## MEMORANDUM

**TO:** Nell Donaldson, Planner  
**FROM:** Lauren Swett, P.E.  
**DATE:** May 12, 2017  
**RE:** 1210 Brighton Ave Hotel Redevelopment, Site Plan Amendment

Woodard & Curran has reviewed the revisions to the proposed hotel redevelopment project located at 1210 Brighton Avenue in Portland, Maine. The project was previously approved, and revisions have been proposed to the building and site features

- Revised Engineering Plans, dated May 8, 2017, prepared by Pinkham & Greer Civil Engineers, on behalf of Portland Hotels, Inc.

4 WOODEN GUARD RAIL SECTION  
C4.5 NOT TO SCALE

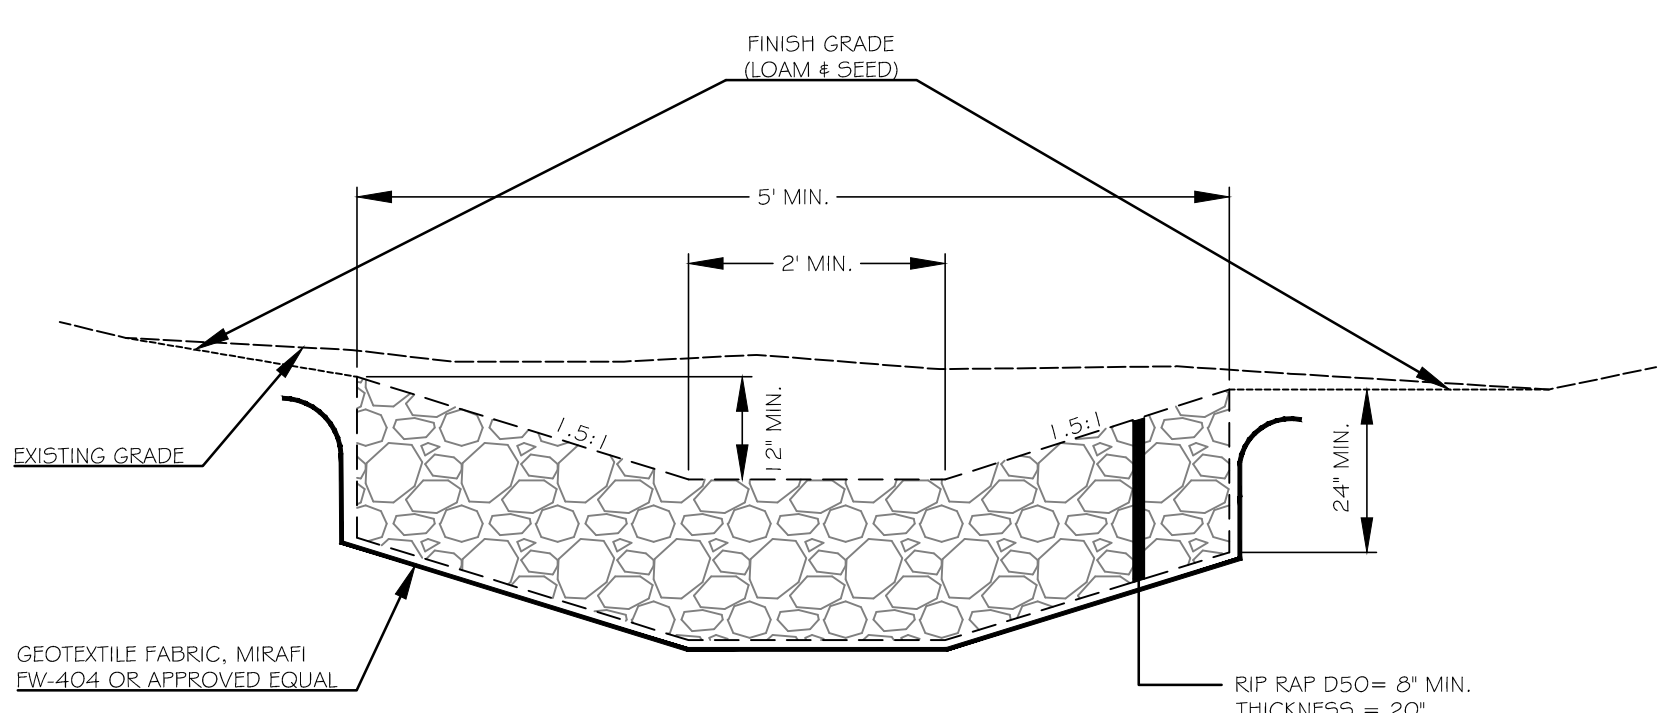
- We recommend that the applicant utilize guardrail along the eastern parking lot edge instead of the curb stops. The guardrail would eliminate the point discharges that will occur between the curb stops. Based on discussions with maintenance staff, the guardrail will also stand up to winter plowing in the parking lot much better than the curb stops typically do.

**2 STRAW MATTING AND TRM EROSION CONTROL**  
 NOT TO SCALE

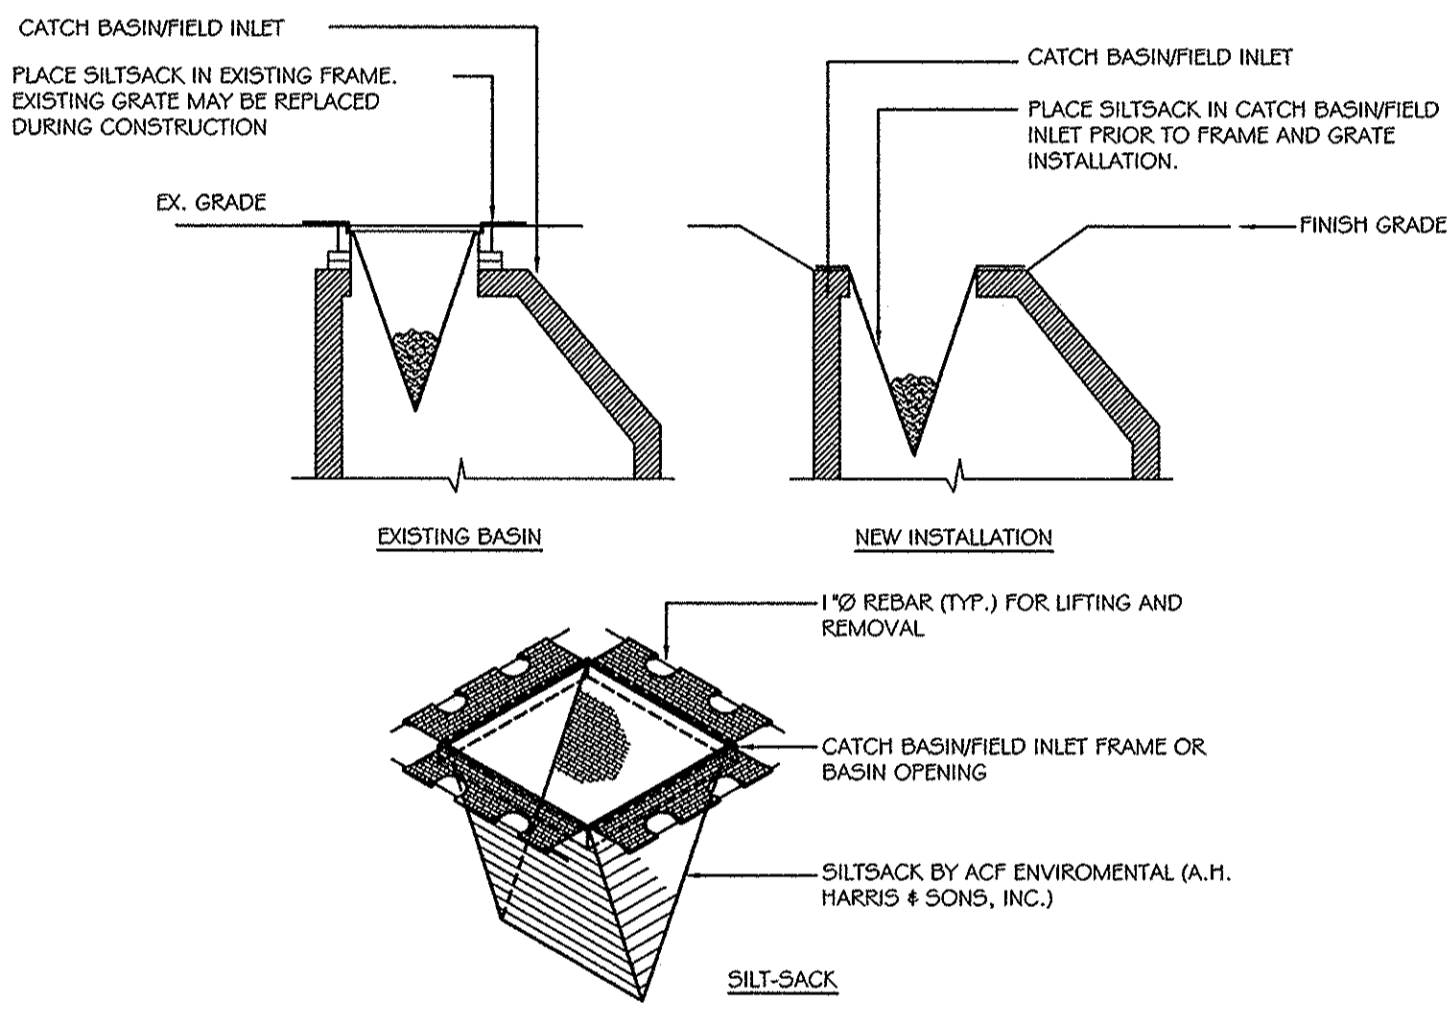
- The Applicant has changed the stormwater drainage configuration at the eastern end of the property. We have the following comments on this change.
  - The plans now note that 6"-deep stilling basins are proposed at the two curb outlets. The landscaping plan identifies that these areas, along with the strip of land along the eastern end of the parking lot are covered with sod. Additional erosion protection should be installed at the two curb outlet areas to ensure that erosion doesn't occur at those locations of concentrated flow. Rip rap or crushed stone is often used for level lip spreaders and velocity dissipaters, but the applicant could consider installing some kind of turf reinforcement matting.

- Sod will provide for a much quicker stabilization of the site than loam and seed, but the success of the sod to prevent erosion due to runoff will be dependent on the growing conditions. The Applicant should ensure that the area is adequately watered so that it stabilizes properly.
